**Application no: 21/02337/DISC**

**Location:** Proposed Himley Village North West Bicester, Middleton Stoney Road, Bicester, Oxfordshire

## **Lead Local Flood Authority**

TITLE
PRELIMINARY DRAINAGE ASSESSMENT
500 UNITS SHEET 2 OF 4

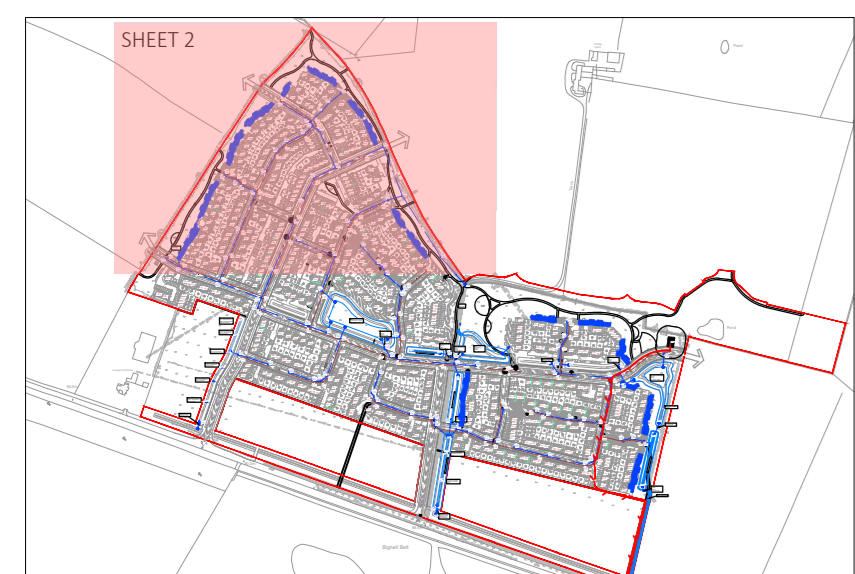
Condition 11 can only be discharged once a site wide strategy has been submitted. Partial strategy could cause flooding issues in the future when other phases are to be built and the run off is affected by the levels or other issues. Hence, a site wide strategy must be submitted to discharge this condition.
